Rosefield Solar Farm – Development Consent Order (DCO) Application

Examination Deadline 2 (22 April 2026)

Environment Agency Response

Figure 3.2: Fluvial Modelling of Claydon Brook Tributary

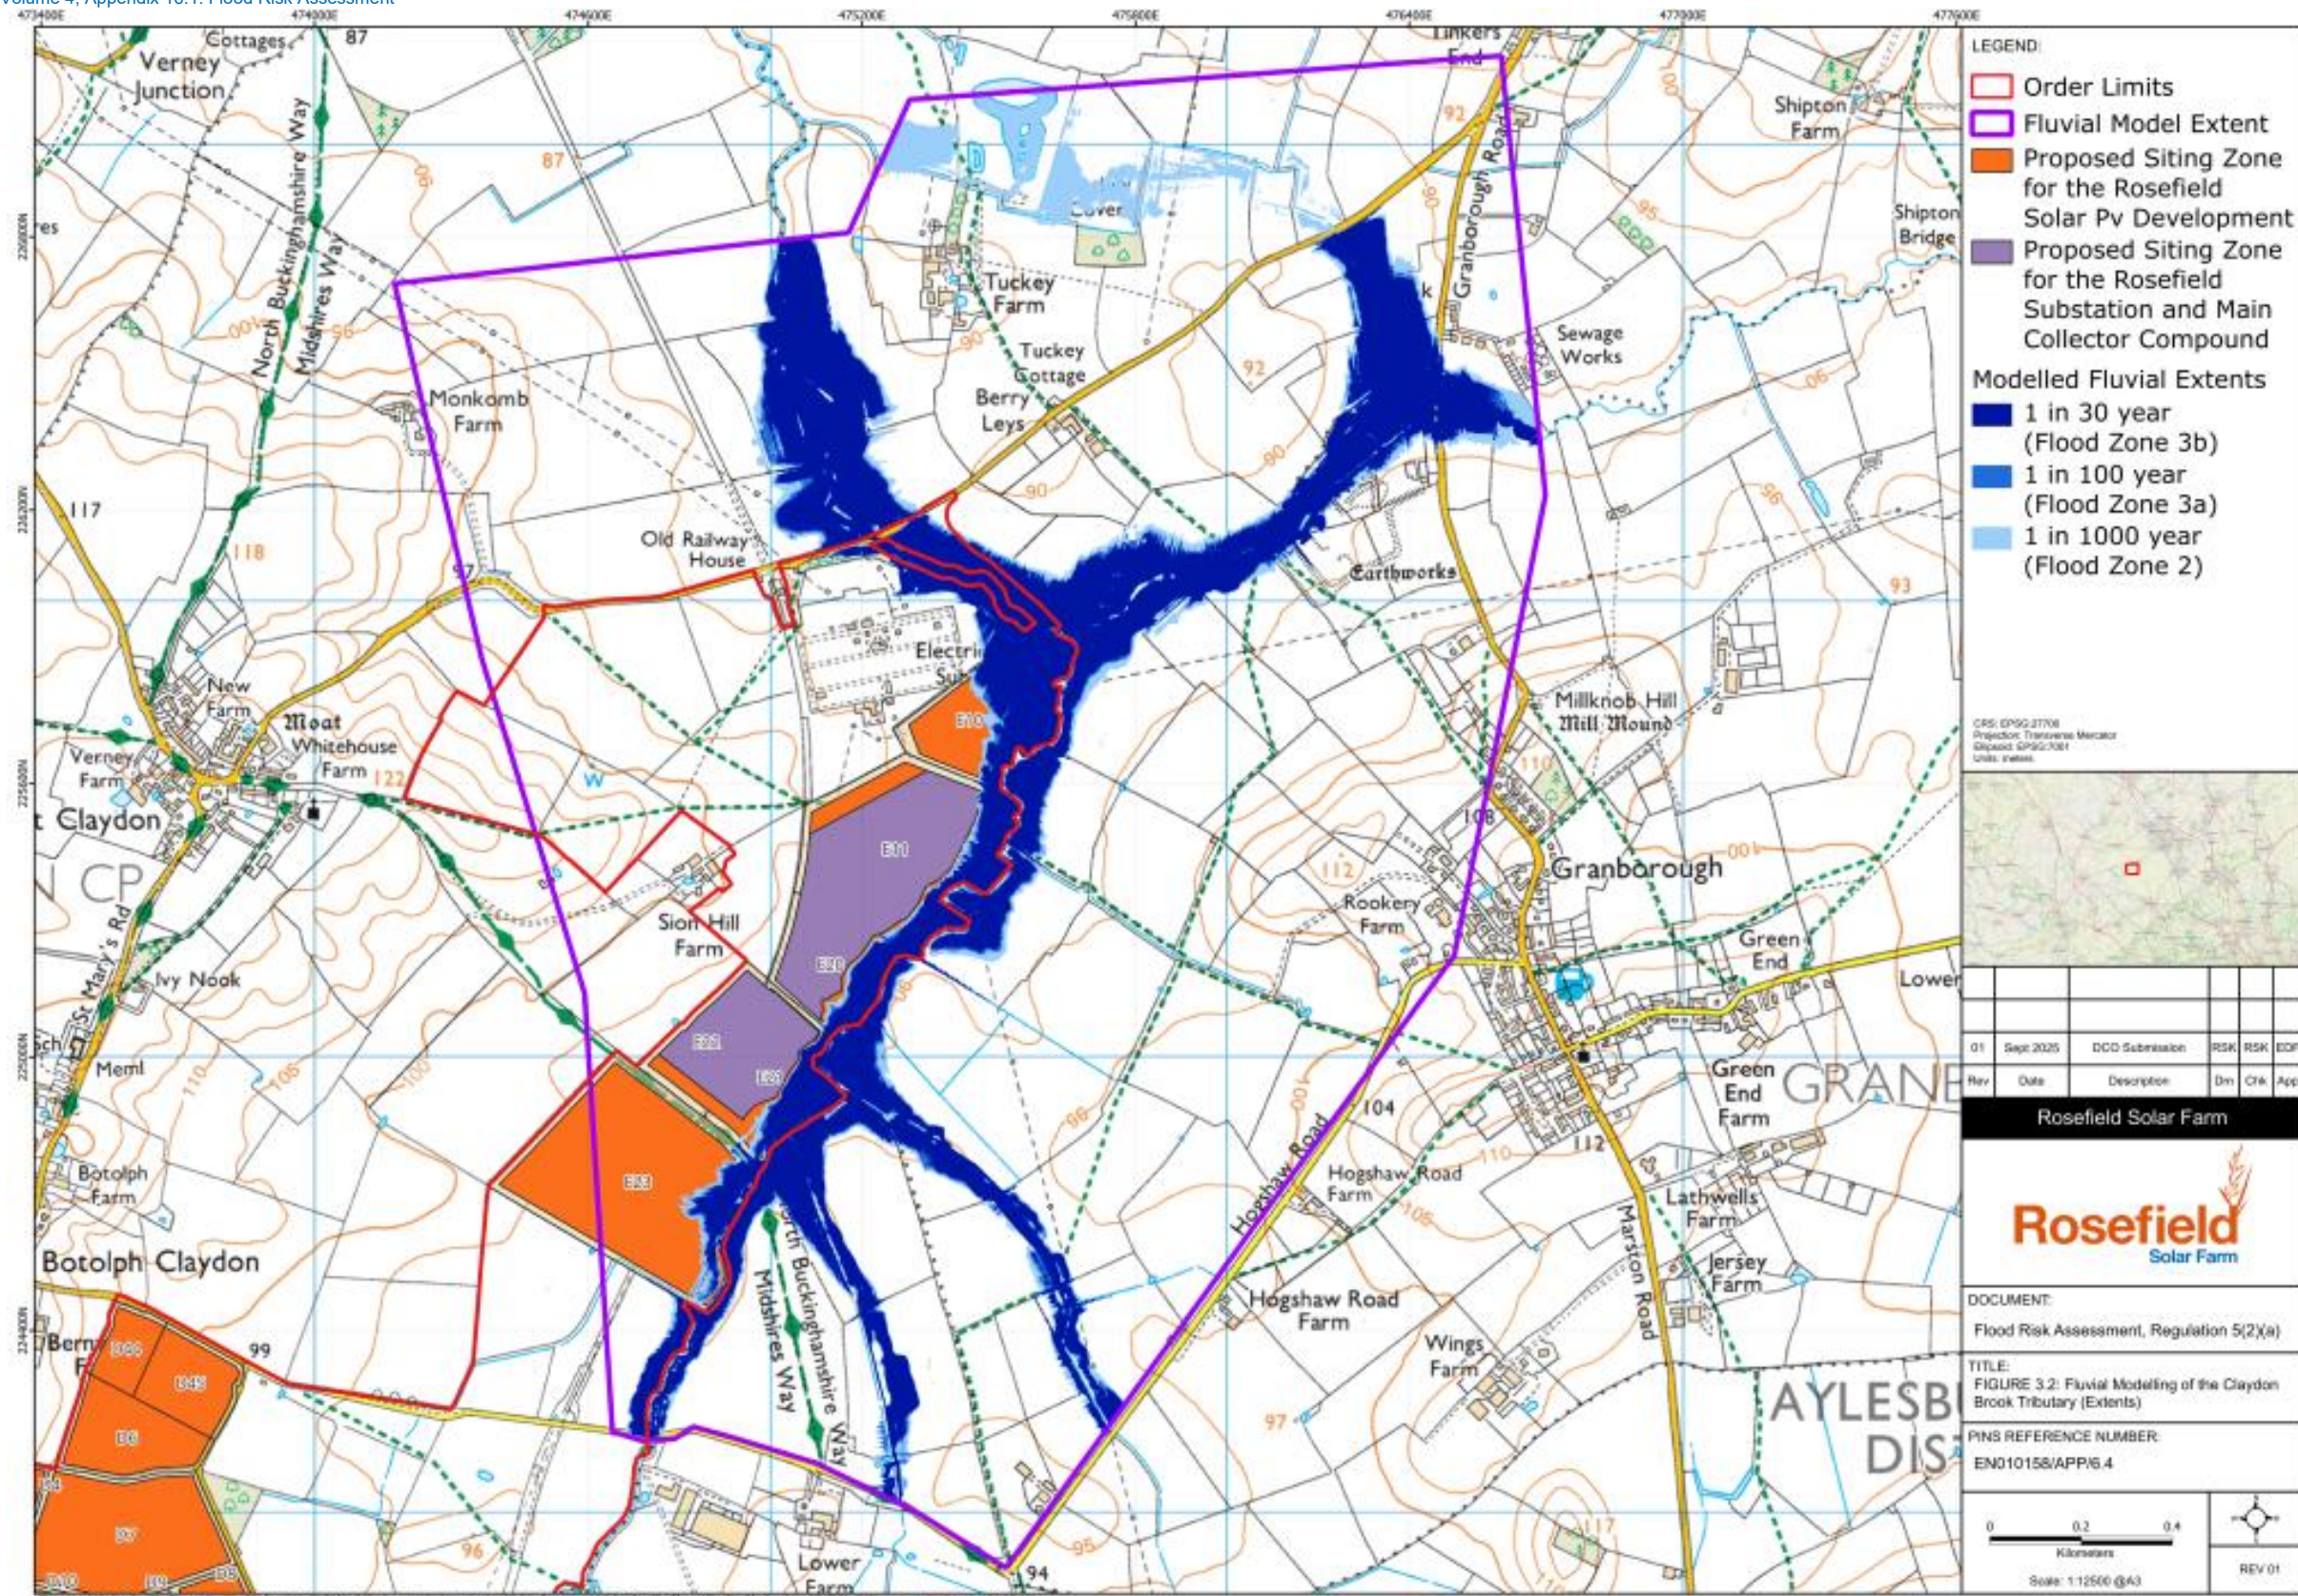
<p>Commitments [REP1-020] secures that Construction Compounds will be located outside of Flood Zone 2 and 3 areas and flood risk from other mapped sources.</p> <ul style="list-style-type: none">• The Applicant has also presented a map showing components relative to Flood Zone 3b in Figure 3.2 of the Flood Risk Assessment [PDA-004]. <p>Our position on these matters is provided in the updated draft SoCG to be submitted by the Applicant at Deadline 2.</p>
--	--	--	------------------------------------------------------------------------------------------------------------------------------------------------------------------------------------------------------------------------------------------------------------------------------------------------------------------------------------------------------------------------------------------------------------------------------------------------------------------------------------------------------------------------
